Response to Submissions (RtS) – Sydney Opera House DA 43-2-2004 MOD 5

This RtS has been prepared by the Sydney Opera House (SOH) in response to comments and issues raised by Heritage NSW and the Department of Planning, Industry and Environment (DPIE) on the proposed Tours Immersive Digital Experience (TIDE) modification application.

Appendix A – response to issues

Appendix B – response to NSW Heritage

Location	Drawing No:	Sheet:	Rev:	
SF GF	49-FB-SC029	CD200	1	A

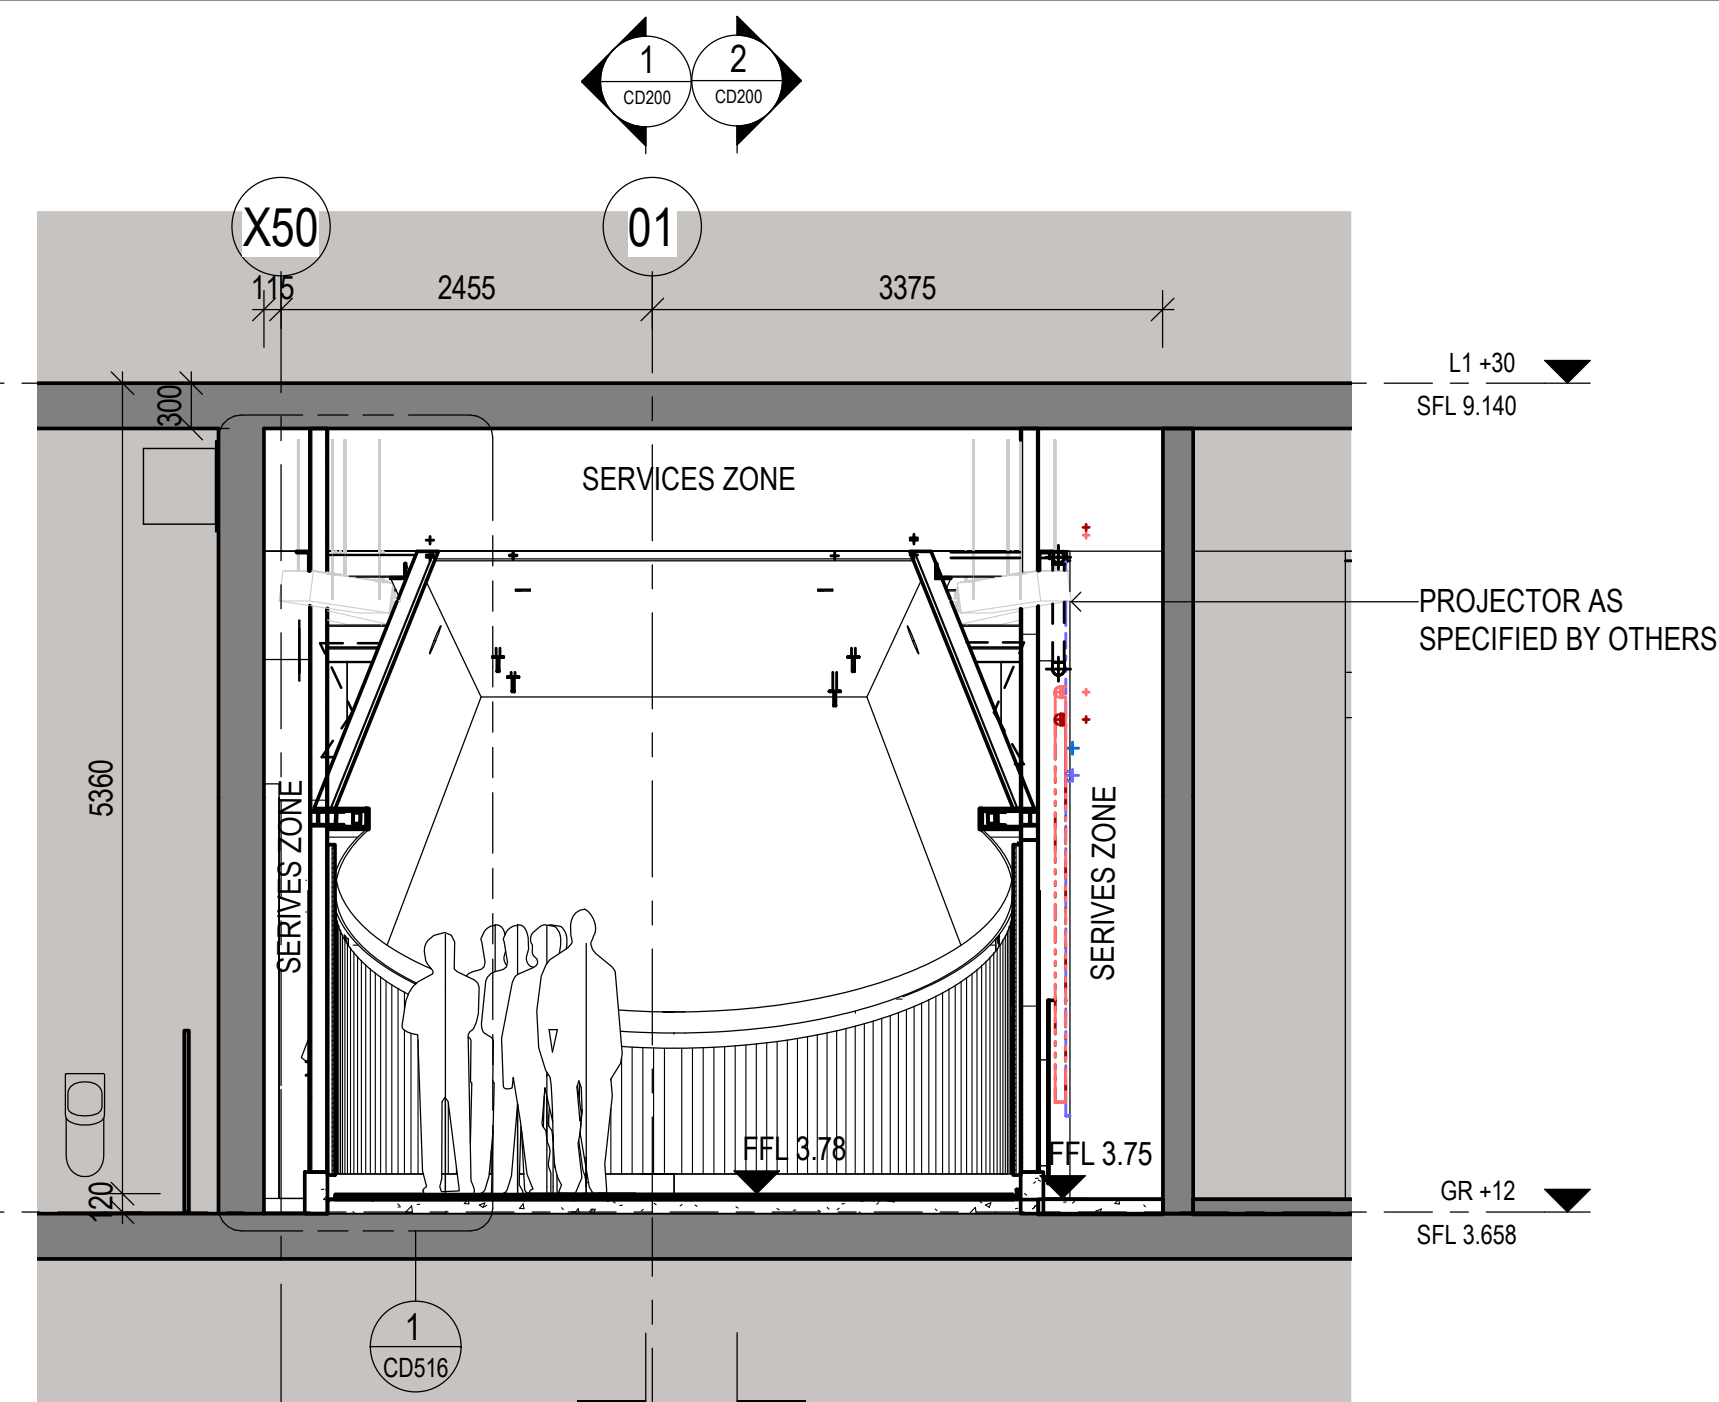
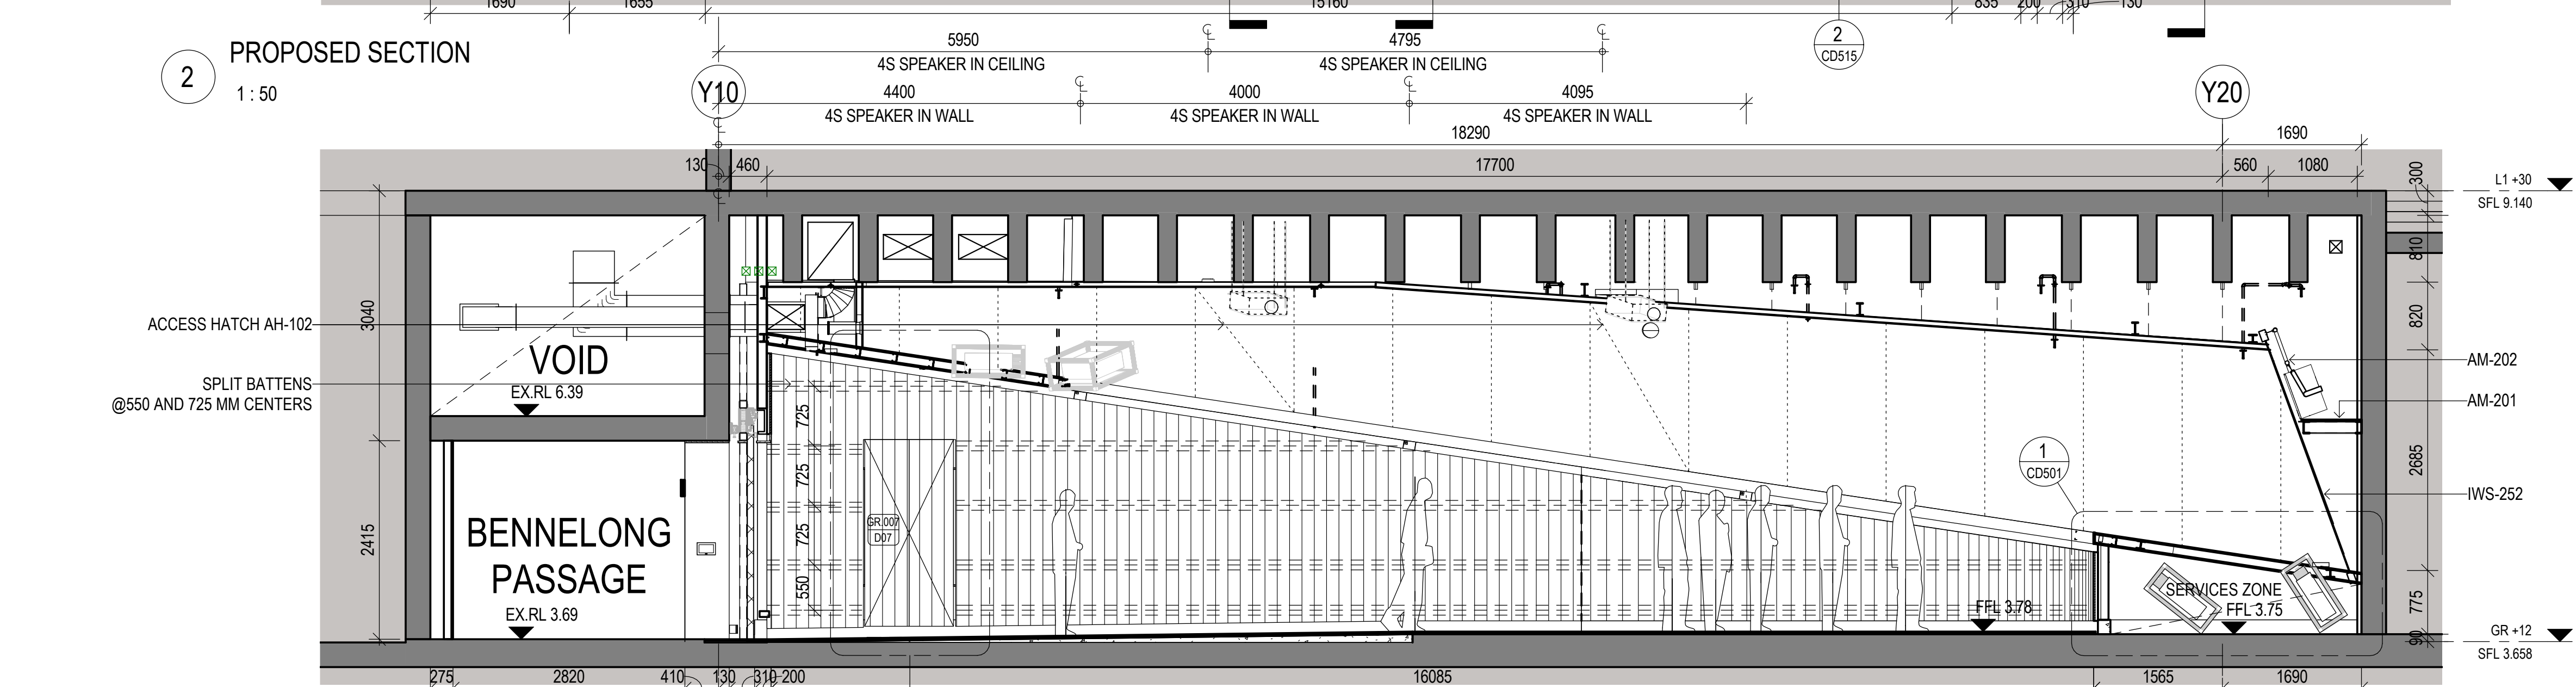
- *The documentation shows a new ceiling will be attached to the existing slab beams above but does not provide details of how this interaction between new and original fabric will be undertaken.*
- *Installation of the new ceiling within the Digital Immersion space should ensure existing fabric including the concrete slab beams, are not impacted by the works and are reversible.*

Sections 1 and 2 in sheet CD2000 and elevation E3/s200 in sheet S250 detail the new structural connections to the existing ribs. Typical ceiling penetrations and connections with the existing ribs are detailed in sheet S255.

These small penetrations into the concrete ribs are necessary to support the TIDE structure and ceiling. The design will minimise penetrations into existing fabric and utilise the new structure for support where possible. Sheet CD200 details the hangers that support the new ceiling.

3 DA SECTION BENNELONG PASSAGE - PROPOSED
1:50

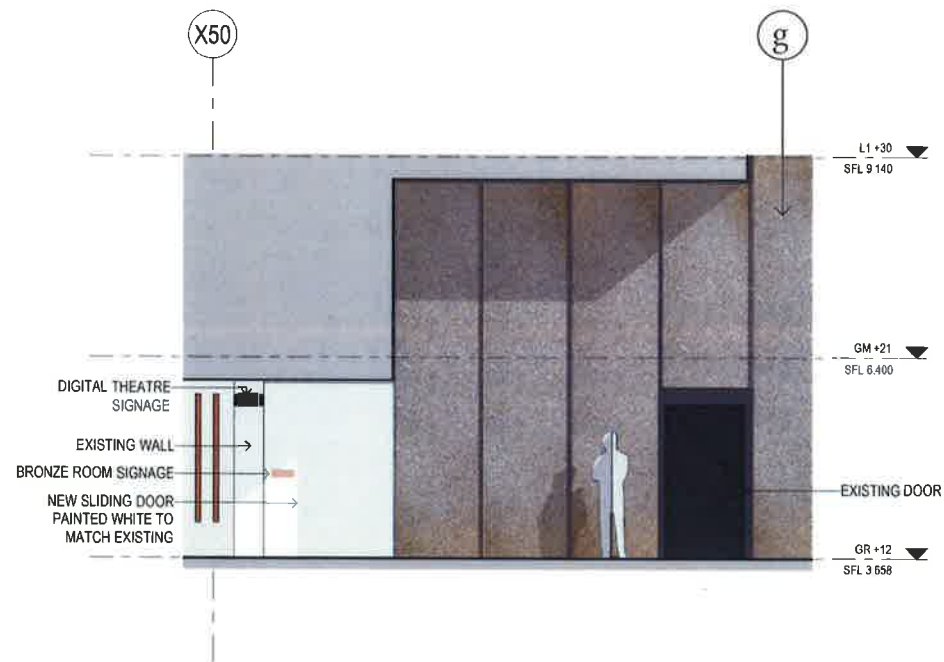
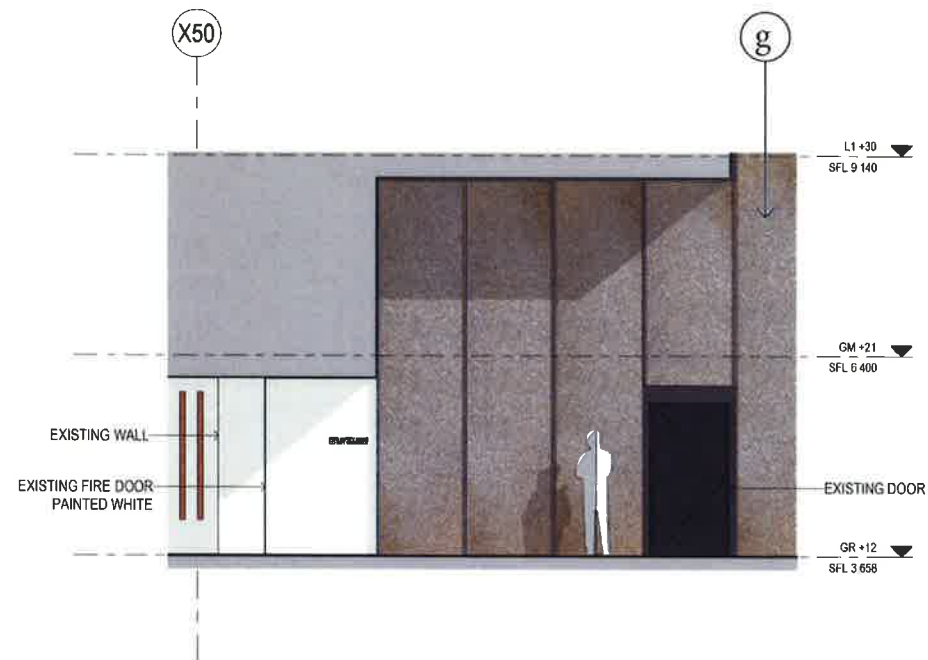
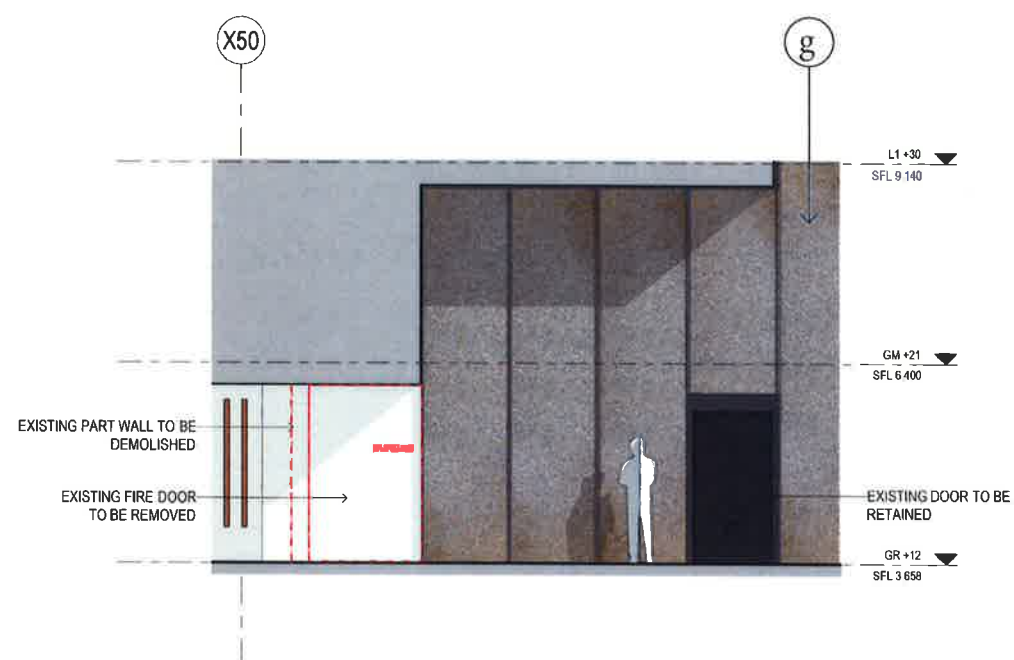
- *It is unclear how the new opening within the 1968 podium structure will be detailed including to the cut edge.*

- *Where elements are proposed to be removed including the floor spring door closers within the Bennelong Passage, fabric is to be made good.*

Elevation E4/s200 within sheet S250 (**Figure 2**) demonstrates the minimal demolition of the 1968 concrete podium wall above the existing opening. This elevation shows the lintel support detail required to form the new door opening. The new lintel will extend 150mm over the opening for structural stability.

Where elements are proposed to be removed, SOH agrees to restore all fabric within Bennelong Passage to its previous condition prior to completion of the TIDE works.
